2207-019 SUB3 - Strand project

Request for SUB3 in the form of review comments on plans (same format as the other requests)

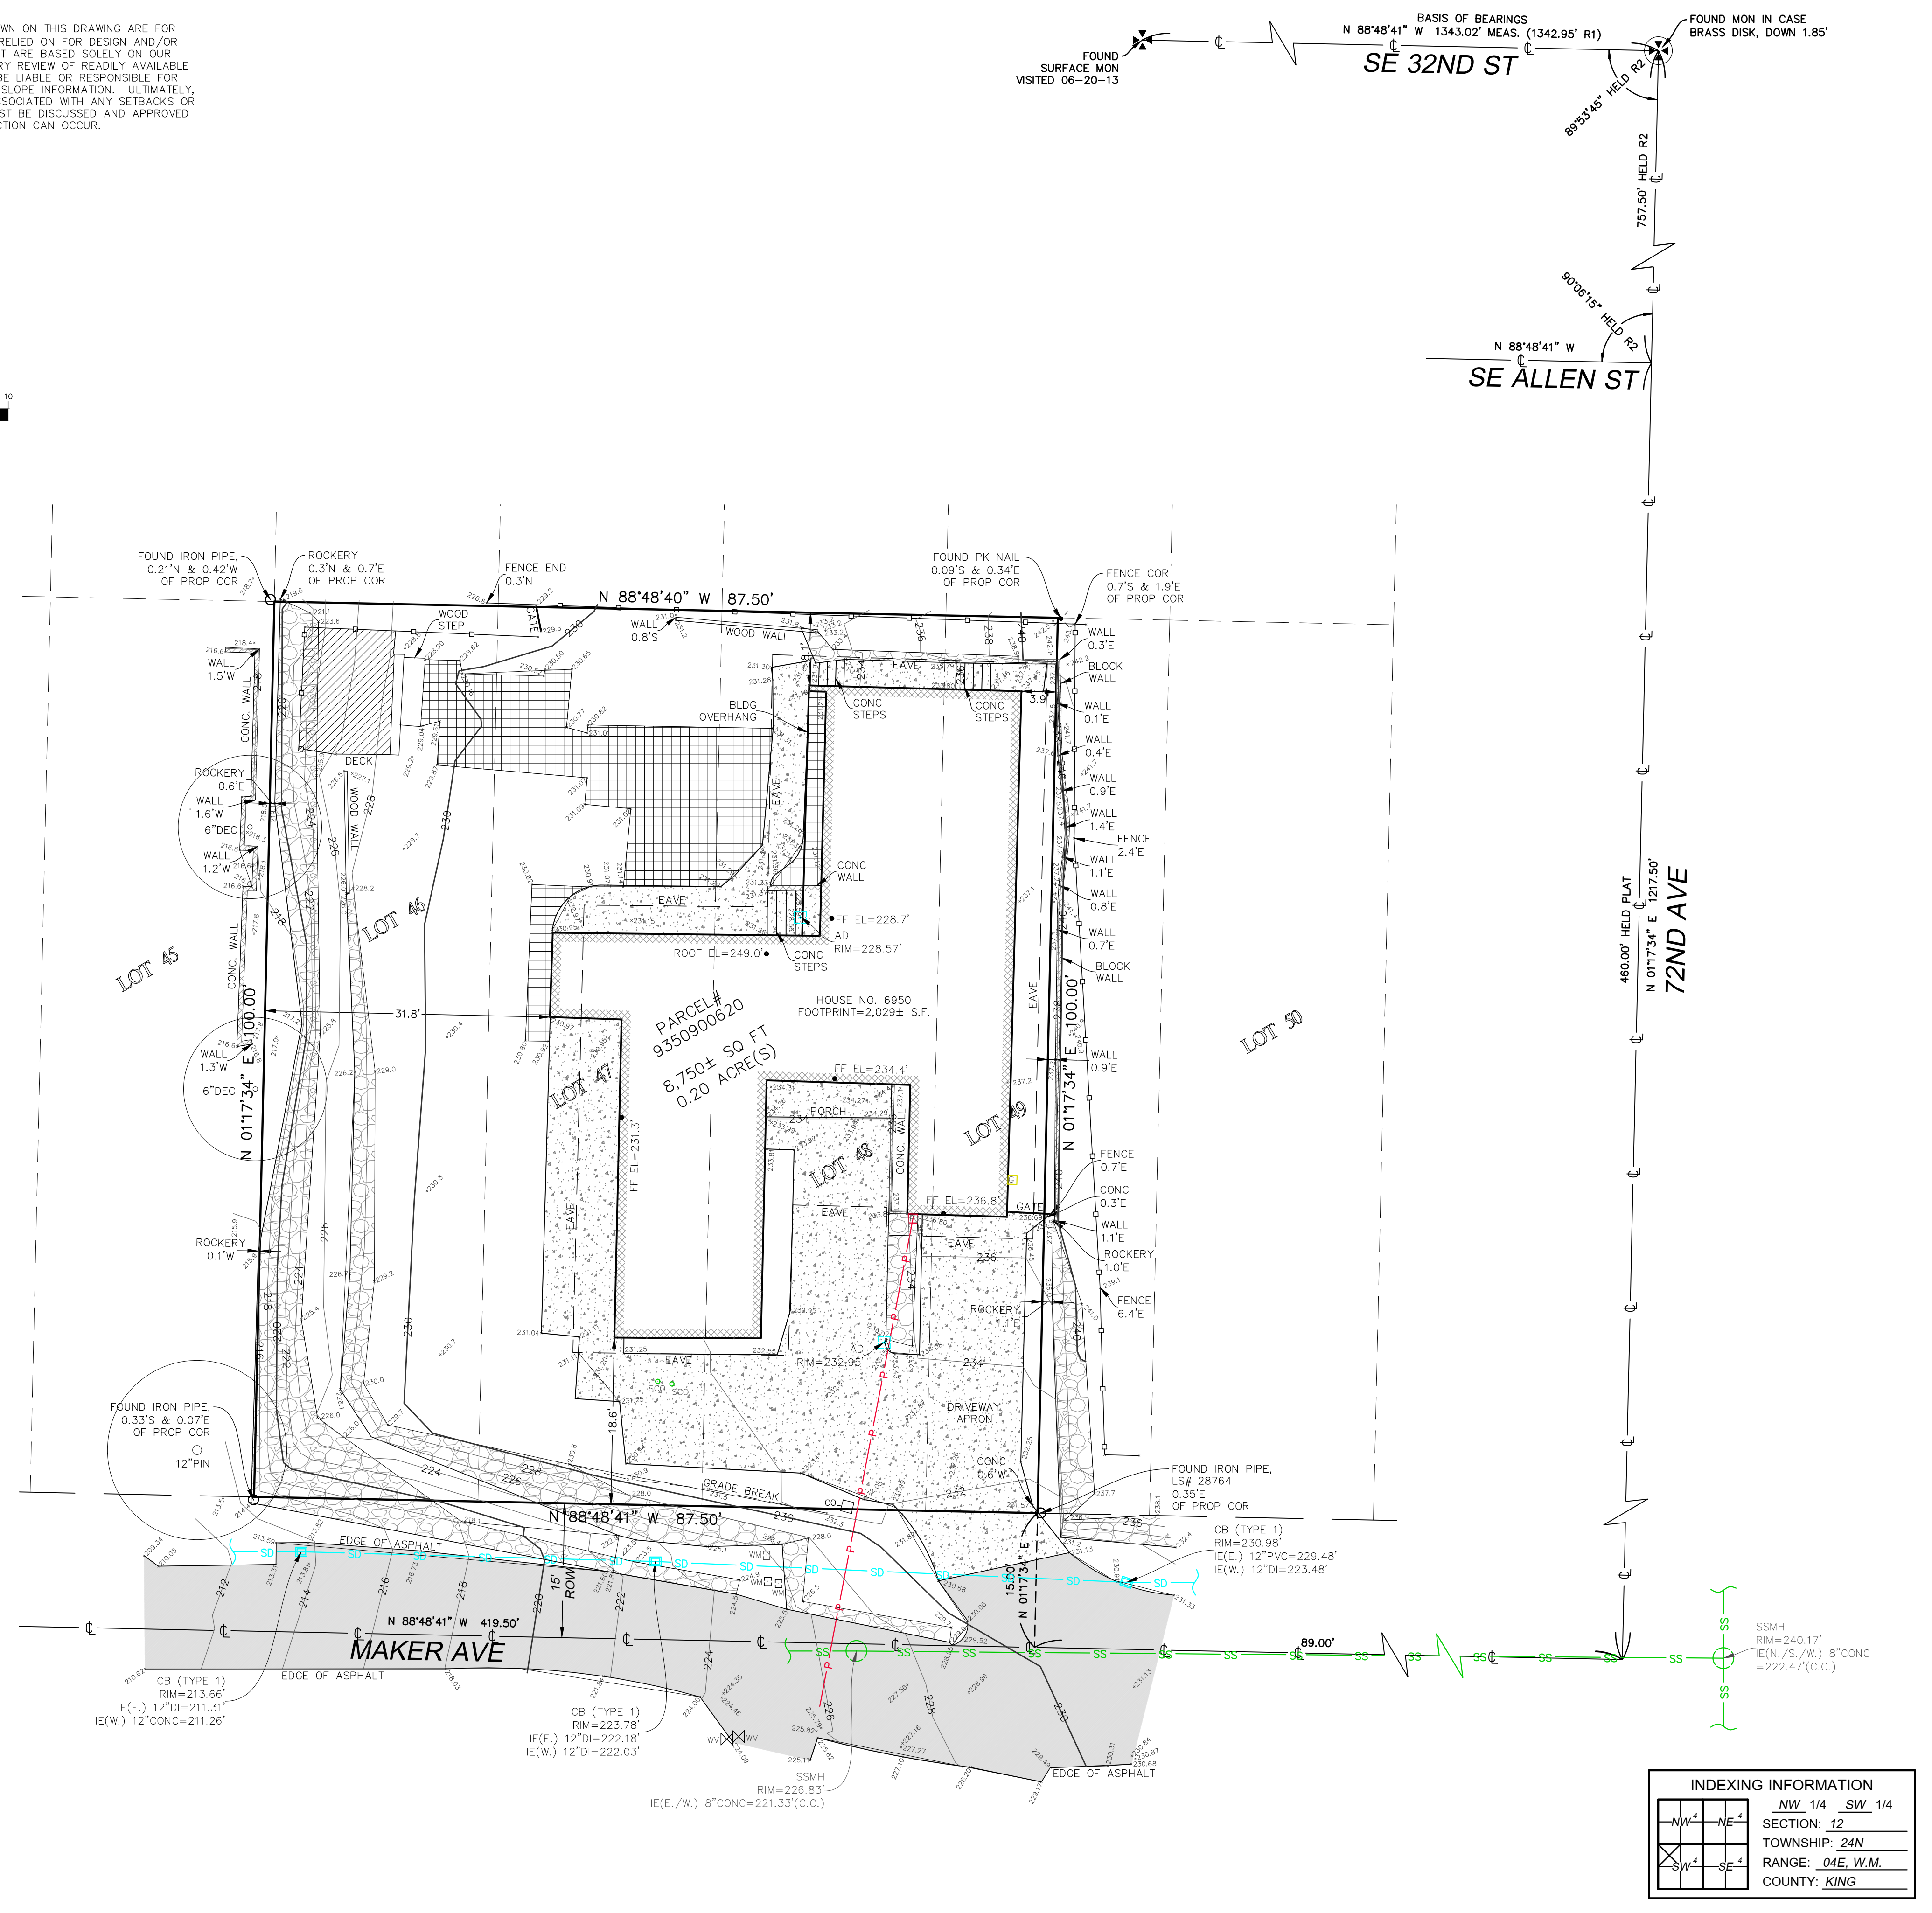
1. Demonstrate existing grade as described in MICC 19.16.010 Definitions:

Existing Grade: The surface level at any point on the lot prior to alteration of the ground surface.

Alteration: Any human-induced action which impacts the existing condition of the area, including but not limited to grading, filling, dredging, draining, channeling and paving (including construction and application of gravel). "Alteration" does not include walking, passive recreation, fishing, or similar activities.

Based on information received from the public, the grade of the lot has been previously altered and the "existing grade" that is shown in the application materials for SUB3 needs additional investigation/exploration. The applicant must provide sufficient information to show the existing grade on the property using one of the following options:

- i. A licensed surveyor must complete the work as described in the Bush, Roed, and Hitchings "Proposed Land Survey Services - Third Party Review" including illustrating the data of all three provided surveys with a common horizontal placement on a map and elevations labeled based on the target datum (NAVD '88) and a survey letter of opinion to highlight relevant findings and determine existing grade. Dan Grove's Letter dated June 9, 2023 has relevant information that may be useful to a licensed surveyor; or

- ii. A licensed surveyor must demonstrate that the existing grade cannot be determined or interpolated using previous surveys of the surrounding area. This should include a letter of opinion and any related materials used to make this determination; or

- iii. The applicant must authorize a third party reviewer (Bush Roed & Hitchings) to perform the work outlined in the "2207-019 Strand Third-Party Review Approval Request" from Molly McGuire dated May 3, 2023.
